**Recommendation:** Refuse

**Applicant:** Mr Tim Catling

**Proposal:** Demolition of existing chapel and erection of 1 dwelling

East Elevation

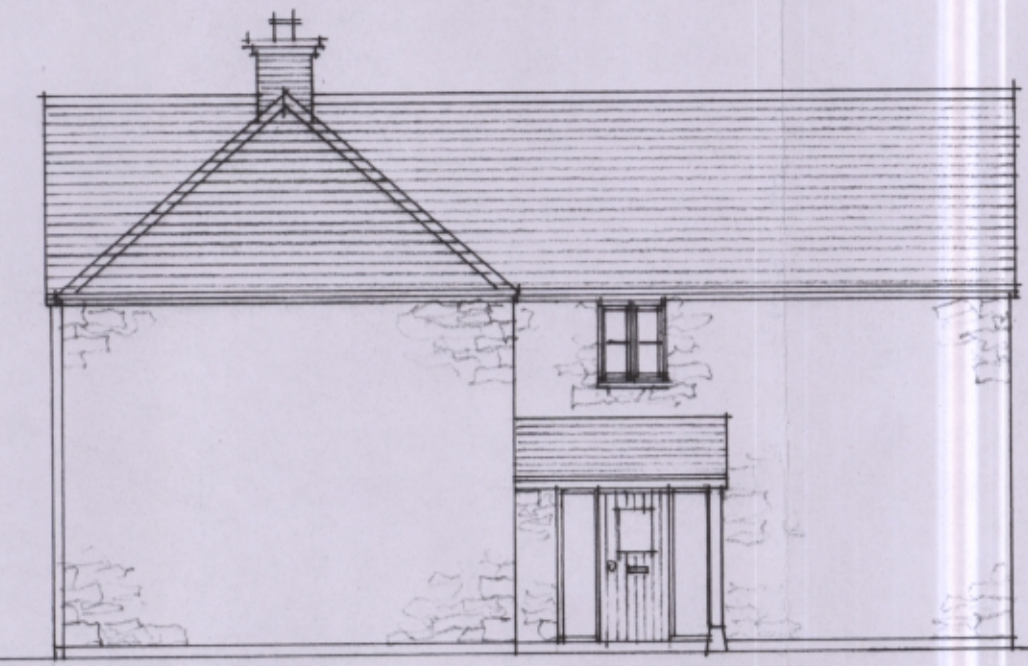
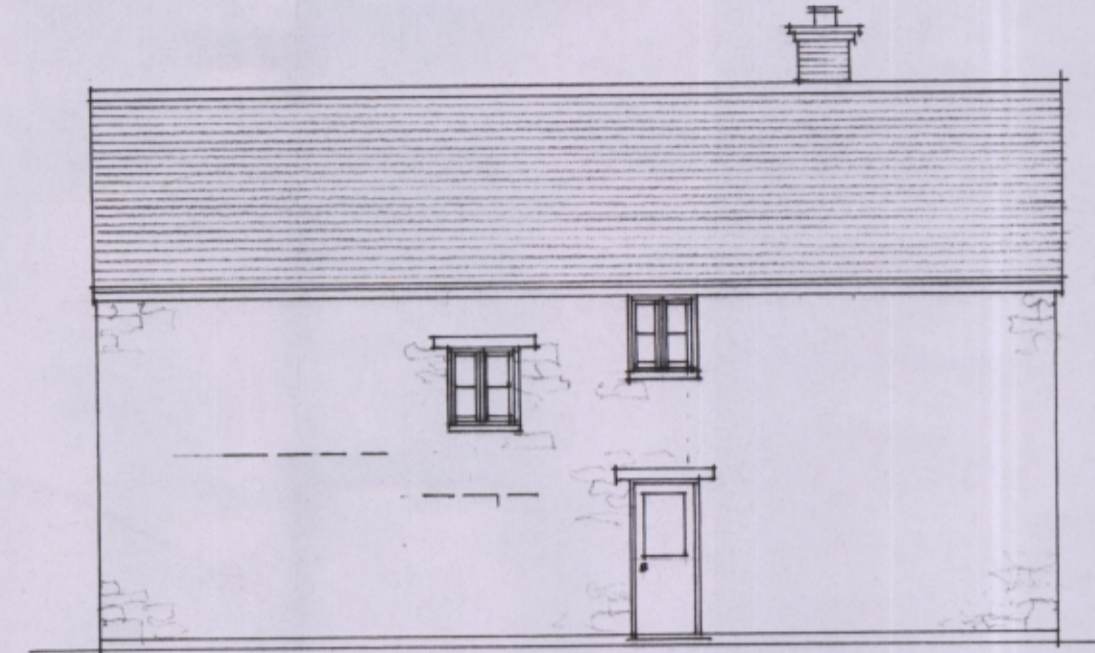
- 8.13. In the consideration of previous applications, it was considered that the proposal resulted in an unbalanced appearance which included one gable end and one hipped end on the front element of the building. Whilst it is appreciated that the current proposal differs from the earlier schemes, the proposal still has an unbalanced appearance – which is exacerbated by a forward projecting gable and a hipped wing perpendicular across the site. Additionally, the bulk scale and massing of this hipped wing is considered to be slightly excessive in comparison to the size of the gable and although set back, would appear incongruous. A more linear form of development along the front of the site (with a rear projecting gable) would be more appropriate in this instance and in keeping with the area.

- 8.14. Hipped roofs are not a traditional feature within the Conservation Area where the majority of properties have gable ended roofs. Whilst it is noted that the neighbouring building has a hipped end adjacent to the site, this part of the building

- 8.20. The side (east) elevation of the dwelling would front towards 13 and 15 Round Close Road. The first floor window of the proposal serves the landing and could be obscurely glazed by way of condition. The proposal contains no other openings on the east elevation and as such would not result in a loss of privacy in this regard. The first floor windows on the west elevation serve a bathroom and stairwell and could again be obscurely glazed by way of a condition. It is, therefore considered that this would not result in any loss of privacy to 1-7 Partridge Court.

Ground Floor Plan 1:100

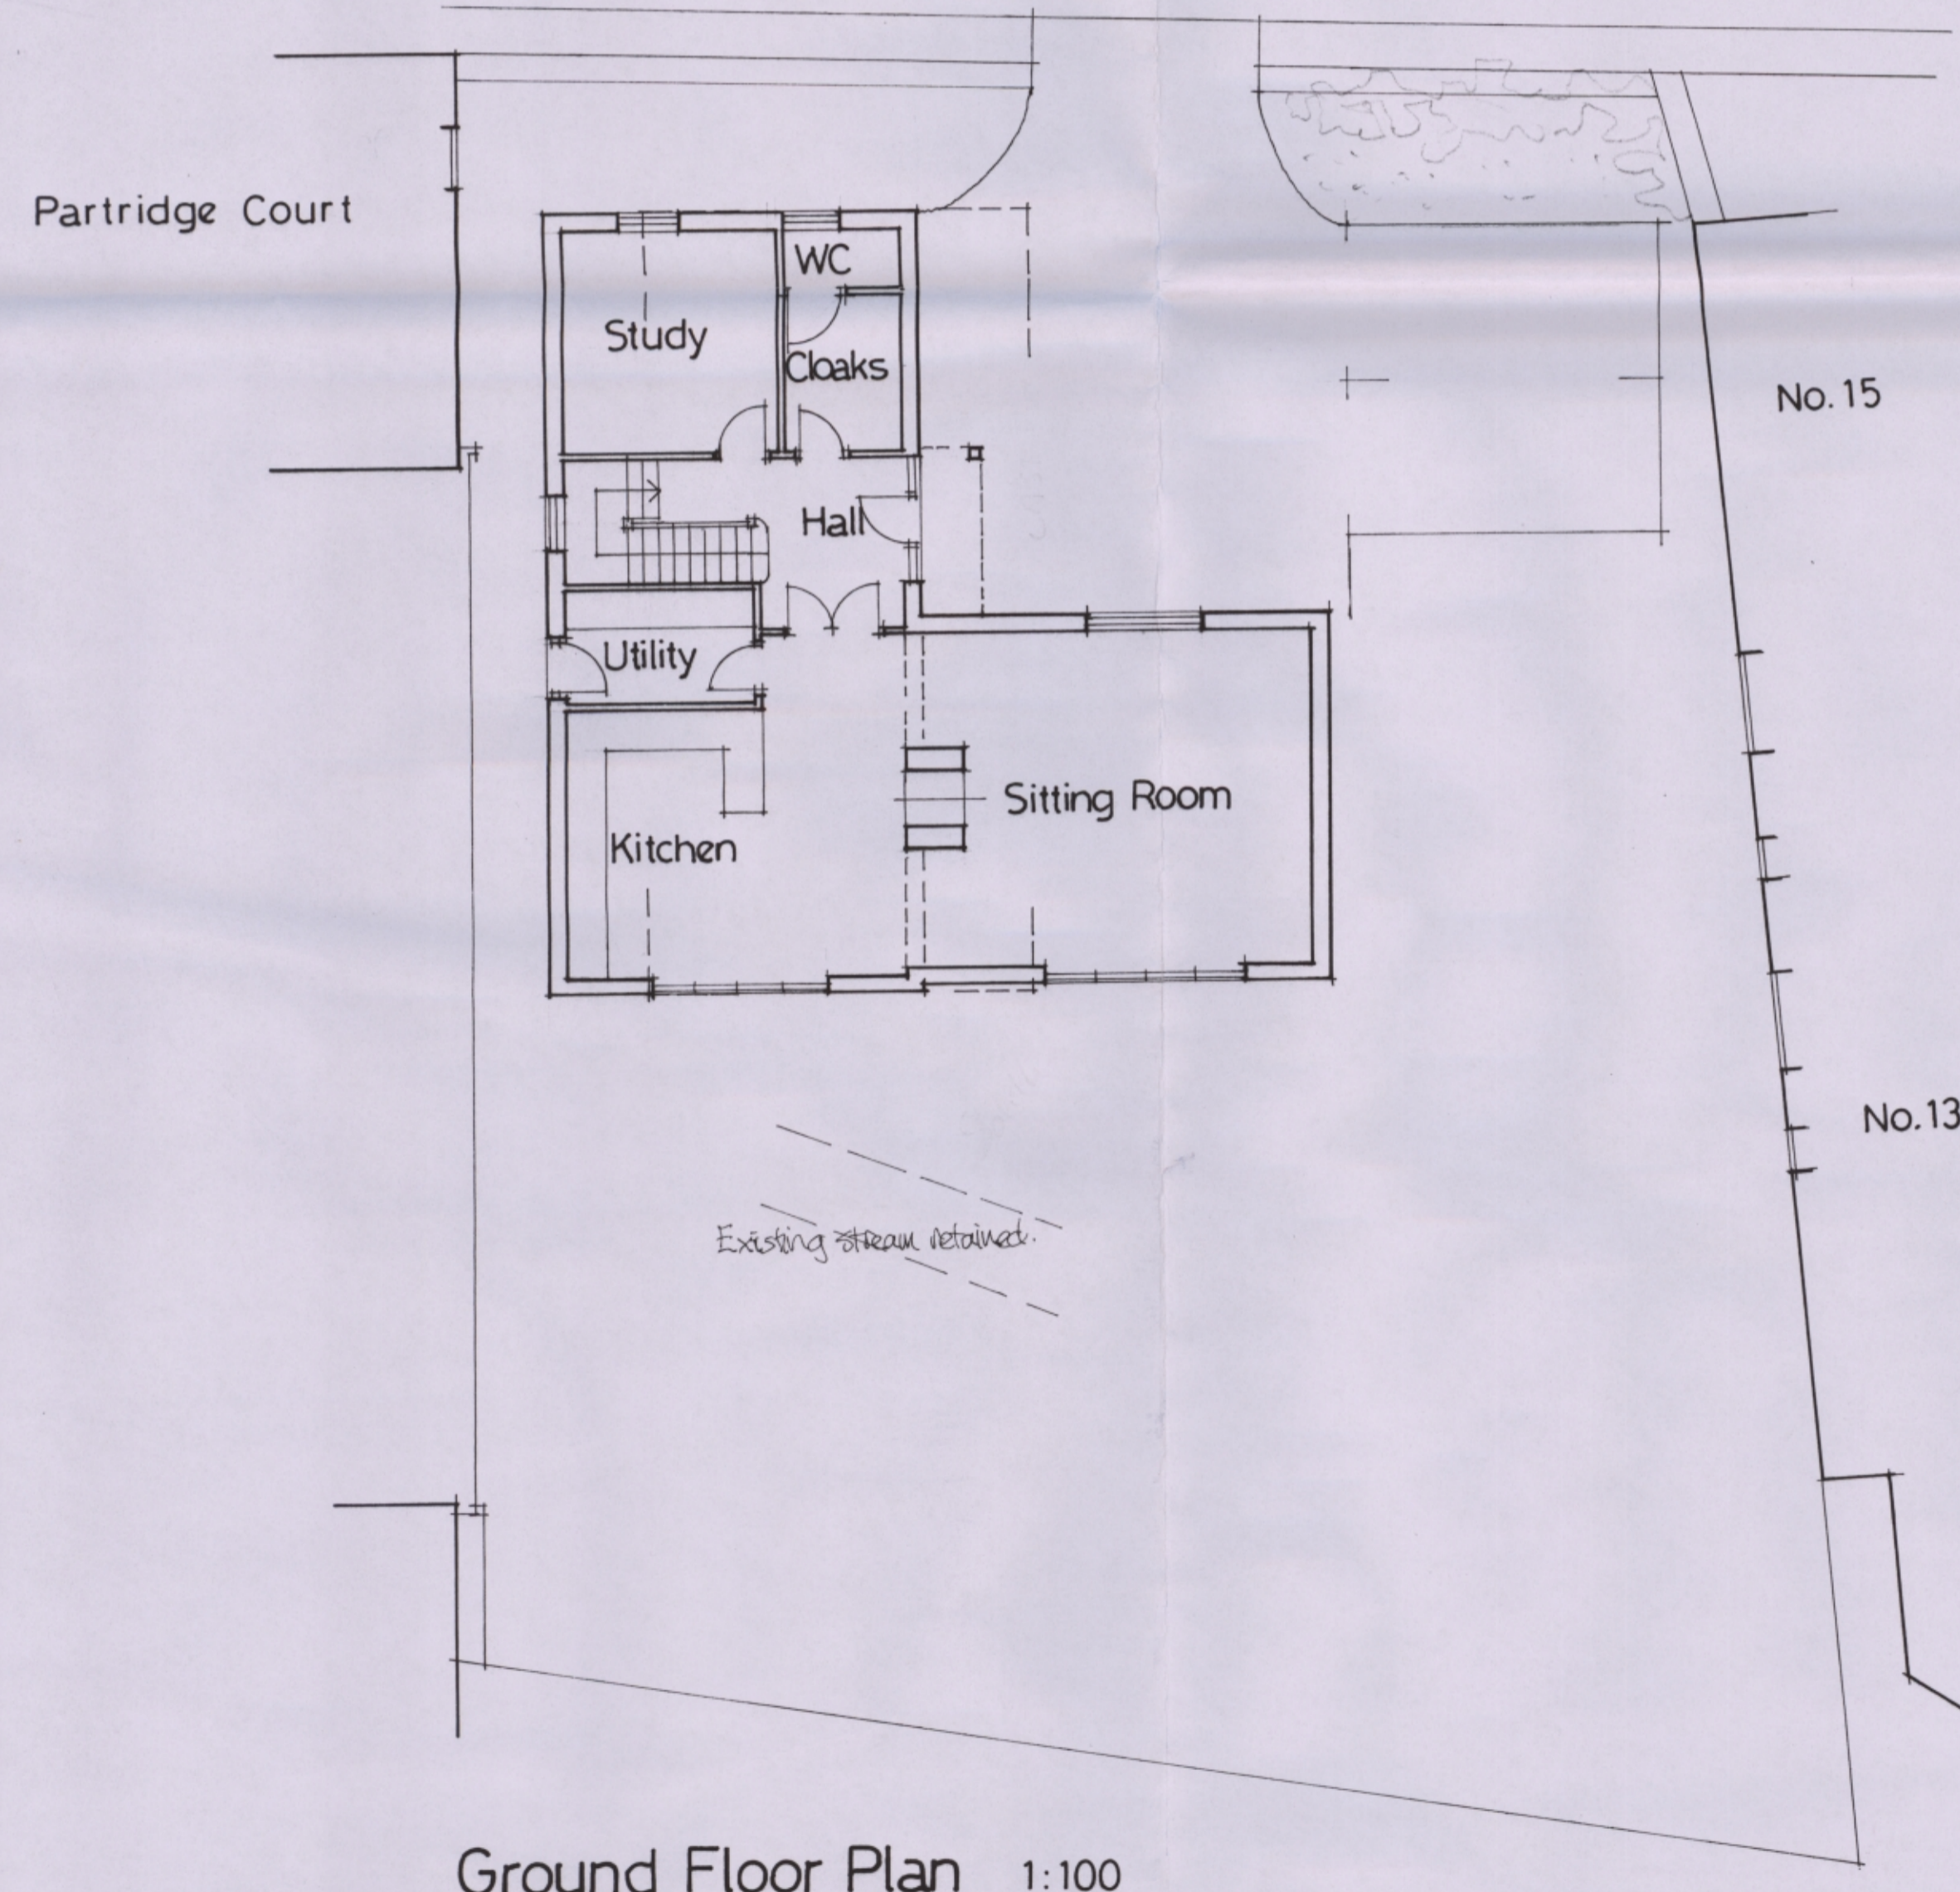
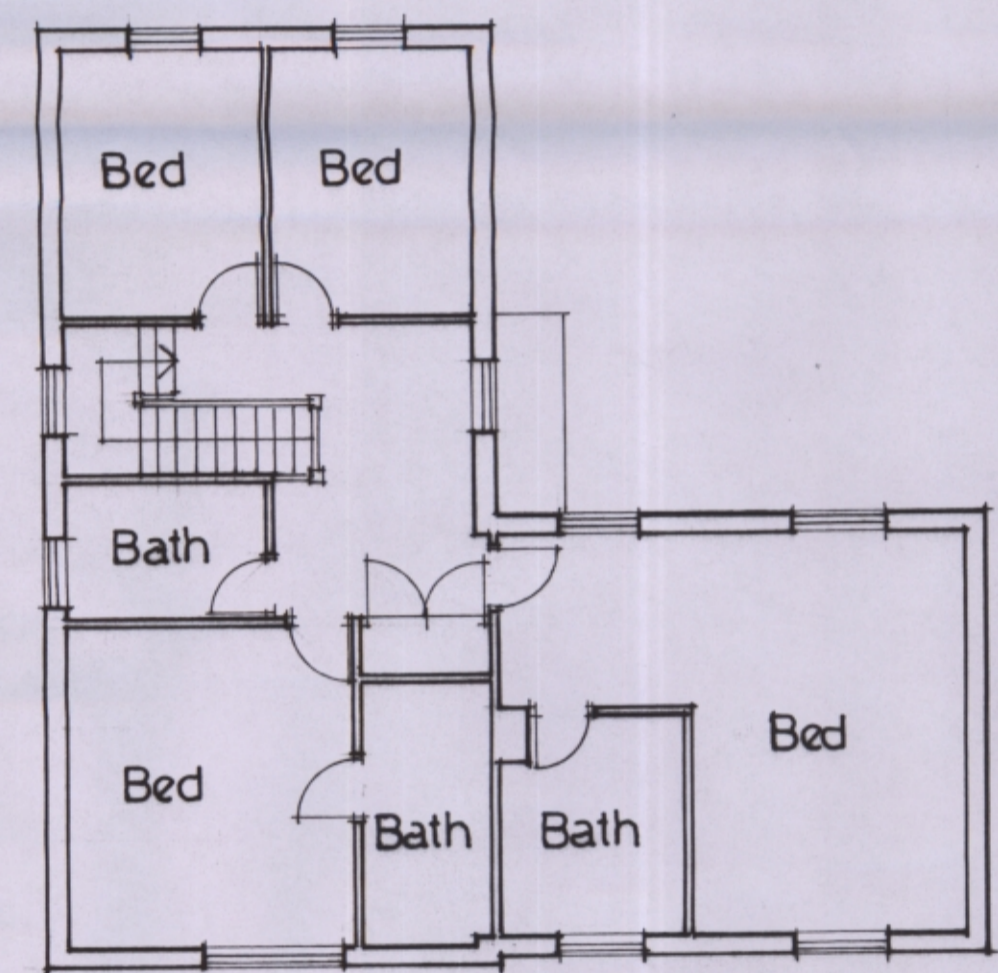
- 8.11. The building would be set back from the front elevation of 1 to 7 Partridge Close by approximately 2.5 (which is approximately in line with the front elevation of 15 Round Close Road). Whilst the building line of the gable is considered to be acceptable, a large proportion of the building is set back from the road (at approximately 9.5m – or 6.5m from the gabled elevation). This is considered to be unfortunate, given that the more traditional buildings in the locality tend to have a stronger and more linear front building line adjacent to the highway (which is prevalent throughout the village of Adderbury) and this is a characteristic of many of the buildings which positively contribute to the Conservation Area. As such, the current proposal fails to create a sense of enclosure to the area which would be in keeping with the character of the designated Conservation Area which is a significant weakness of the scheme. Furthermore the layout of the frontage would car parking and manoeuvring space would rather dominate the frontage of the site which would detract from the character and appearance of the Conservation Area

- 8.21. Notwithstanding the above, the side projecting hipped element would be within 6.5m of the ground floor window of 15 Round Close Road. The Council's Home

- 8.22. Further to the above, the private amenity space of the proposal dwelling would be immediately adjacent to the windows of 13 and 15 Round Close Road. Policy ESD15 of the CLP 2031 (Part 1) requires the LPA to consider matters of amenity of both existing and future development, including matters of privacy, outlook, natural lighting, ventilation, and indoor and outdoor space. There will be a clear conflict between the privacy of the neighbouring properties (through which there would be a loss of privacy) and the privacy of the future occupiers of the application site (which will be severely overlooked by the neighbouring occupiers). As such, it is considered that the proposal fails to provide an adequate standard of outdoor amenity space for the proposed occupier which would also be to the detriment of the privacy of the neighbouring occupiers.
